Sizewell C (SZC)

Planning Inspectorate Reference: *EN010012*

Deadline 3 – 24 June 2021

Comments by registered Interested Parties on Written
Representations

DRAWING NO:
SZC-SZ0100-XX-000-DRW-100207

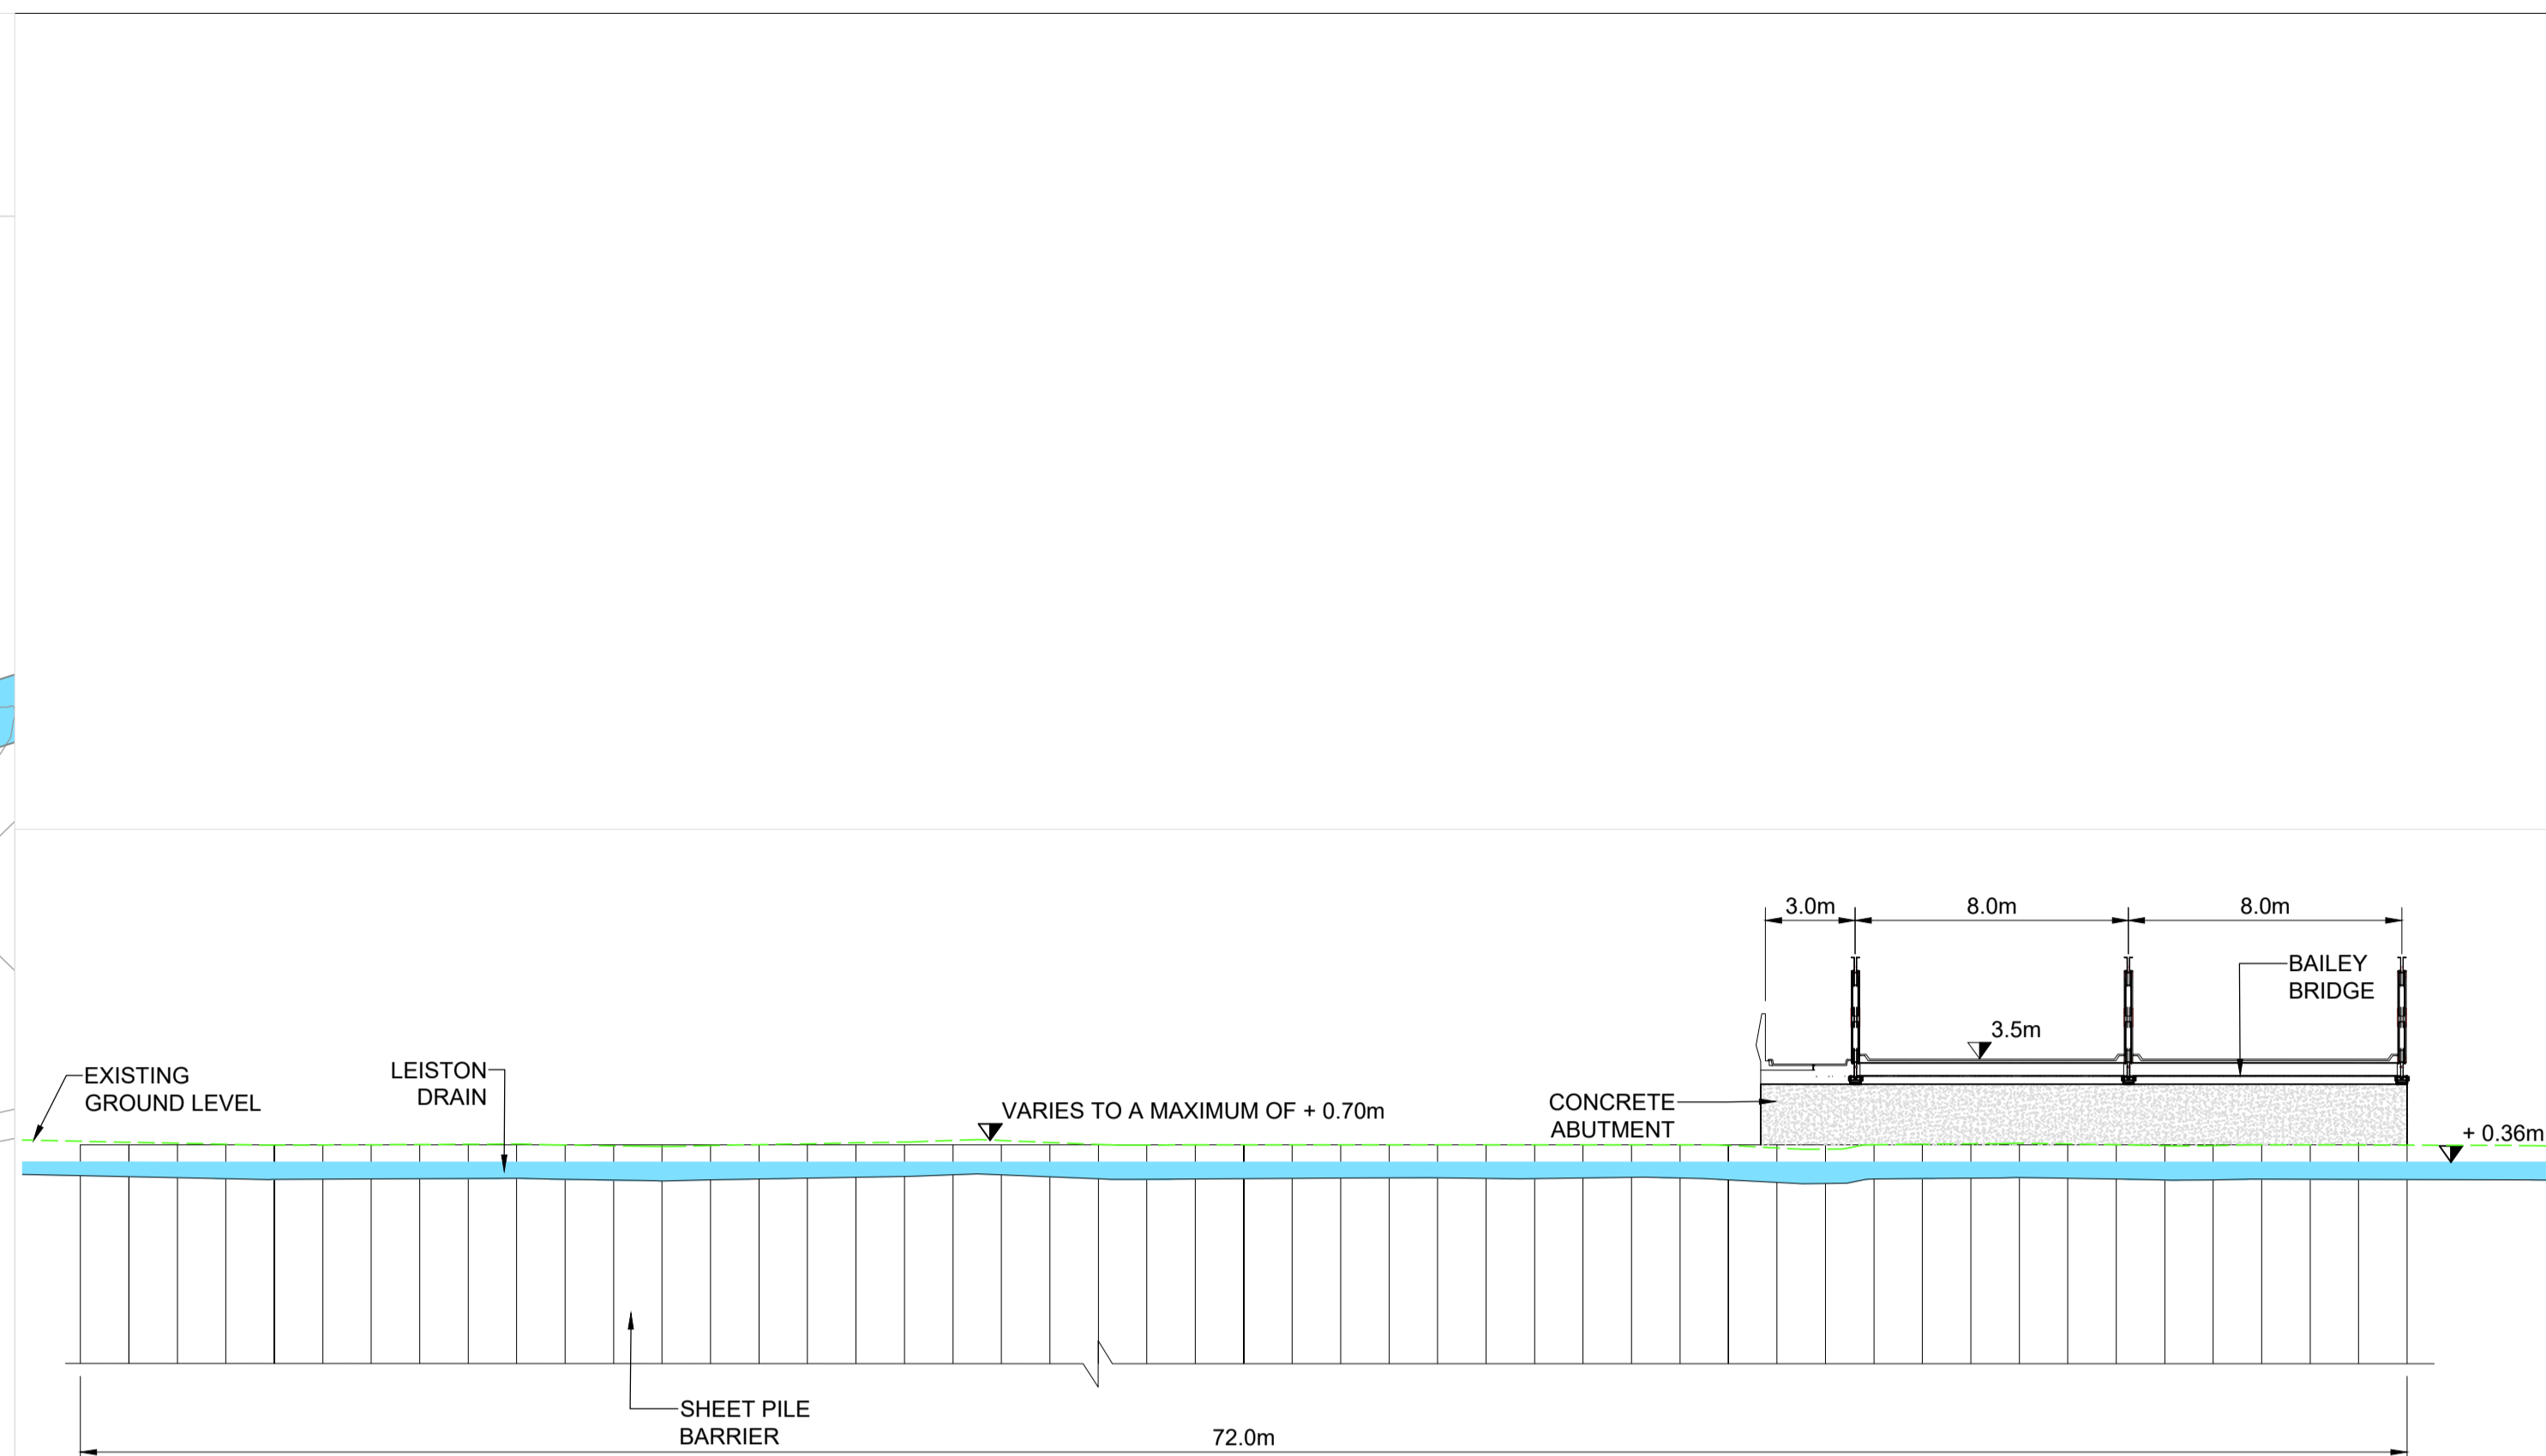
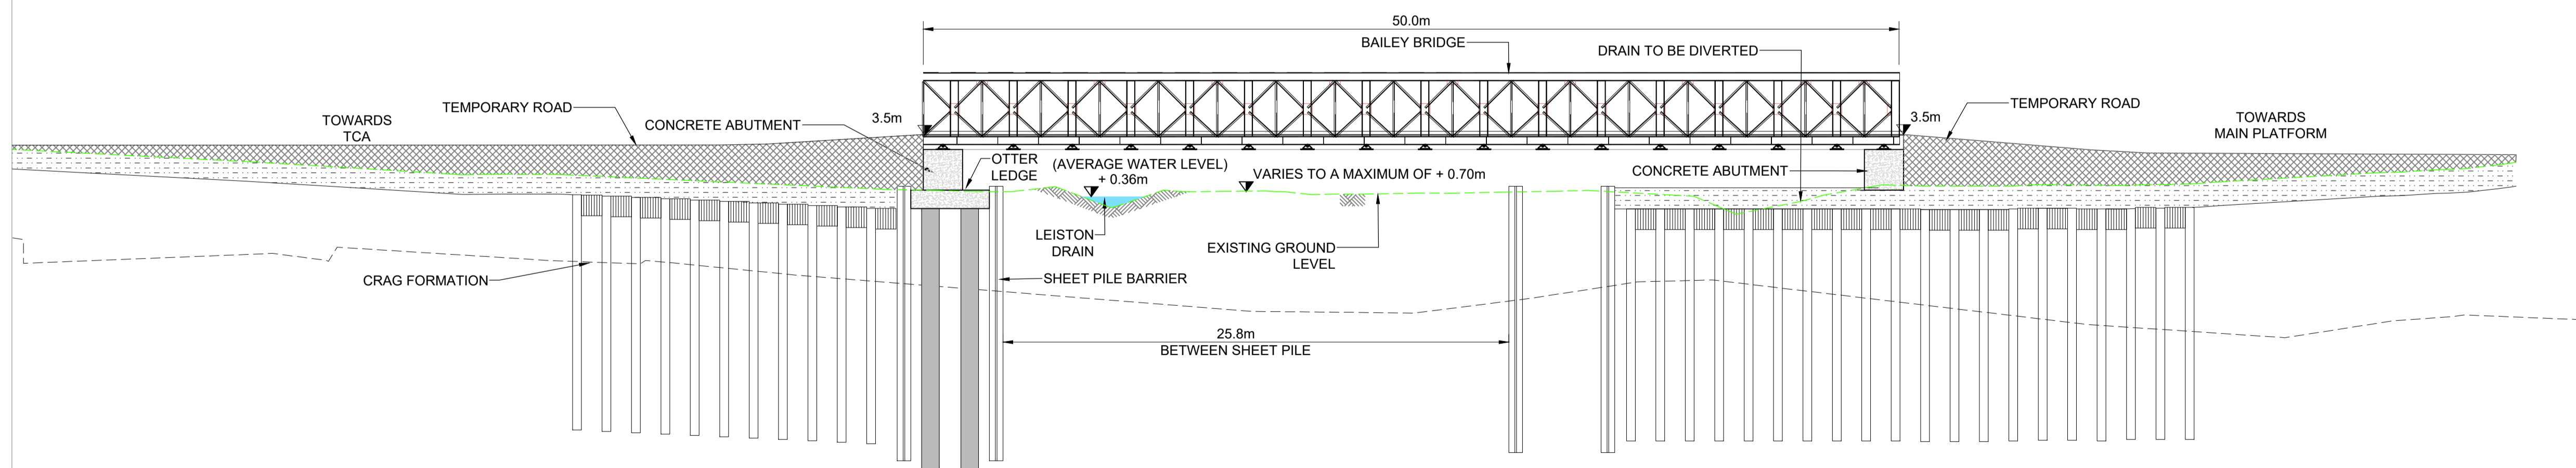
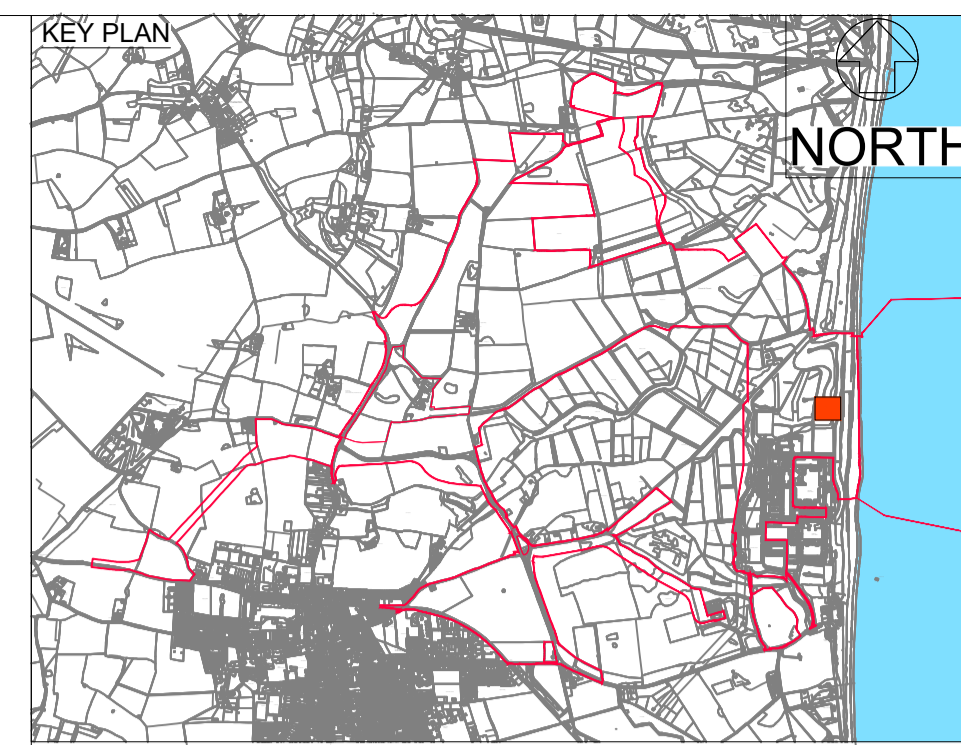
- 5.1. ESC considers that the proposed hybrid causeway / open span bridge in the application offers a reasonable compromise to previously requested fully open three span bridge options (paragraph 8.39 [[REP1-045](#)]) seen in previous rounds of public consultation (pre-application).

- 5.2. ESC appreciates the concerns highlighted by other parties with regards to potential impact on species connectivity, in particular invertebrates. ESC is of the opinion that the causeway provides an opportunity for landscaping of the crossing that would be beneficial in the longer term from a Landscape and Visual Impact Assessment perspective (paragraph 8.41 of the LIR [[REP1-045](#)]).

- 5.3. ESC would like the Applicant to consider revisions to the design of the bridge and embankment to further reduce its ecological impact. For example, as in the LIR (paragraph 8.42 [[REP1-045](#)]), ESC considers that an increase in height of the bridge above that proposed (i.e., > 4m) (which may involve a slight raising of the deck height of the carriageway) would be beneficial for species connectivity, such as some species of invertebrate (particularly those which see by positive phototaxis such as dragonflies

and damselflies), by increasing light availability. We welcome the Applicant's suggestion that they will be able to revise the design further and we look forward to seeing further details at Deadline 4.
